RE: REVISED DRAINAGE PLAN FOR PIEDRA LIST COURT
(H-22/D61) REVISION DATED APRIL 14, 1988

RE: REVISED DRAINAGE PLAN FOR PIEDRA LISA COURT
(H-22/D61) REVISION DATE OF MARCH 21, 1988

RE: DRAINAGE PLAN FOR PIEDRA LISA COURT
(H-22/D61) RECEIVED FEBRUARY 23, 1988

**Piedra Lisa Court**  
 2520 JUAN TABO BOULEVARD N.E.  
 ALBUQUERQUE, NEW MEXICO

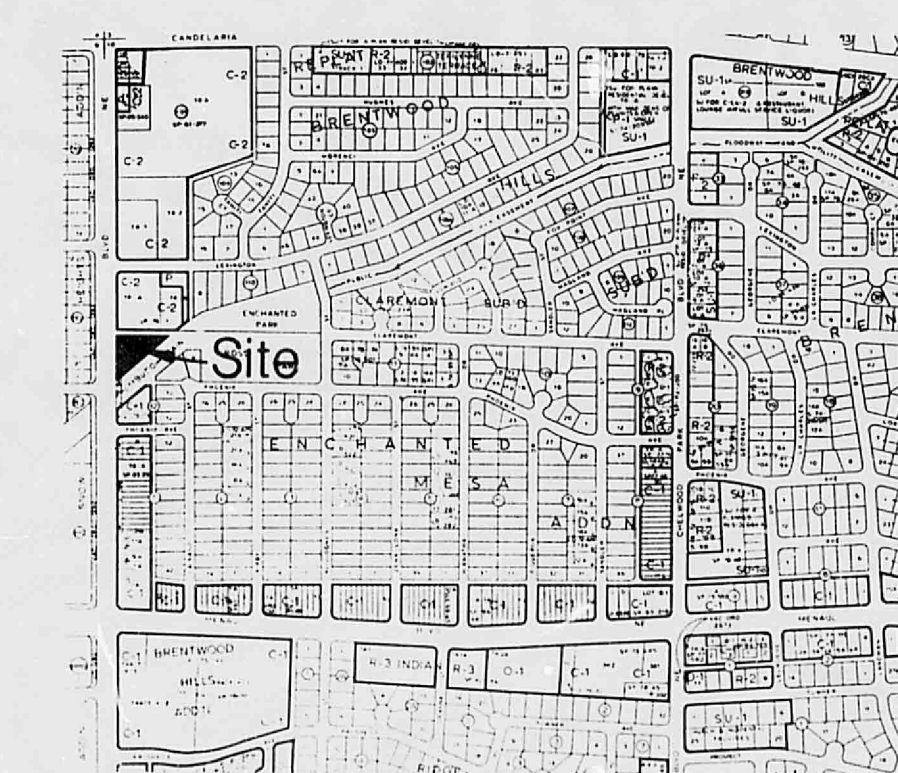
Based on the information provided on your resubmittal of March 21, 1988, the only concern that remains to be answered prior to building permit release is the location and type of storm drain inlet to be used.

1. Location, description and elevation of the ACS Bench Mark used.
2. Description of T.B.M. (should be a curb cut or painted mark).
3. Storm drain inlet at the north end of property on Juan Tabo must be installed (change must go through work order process at D.R.C.).
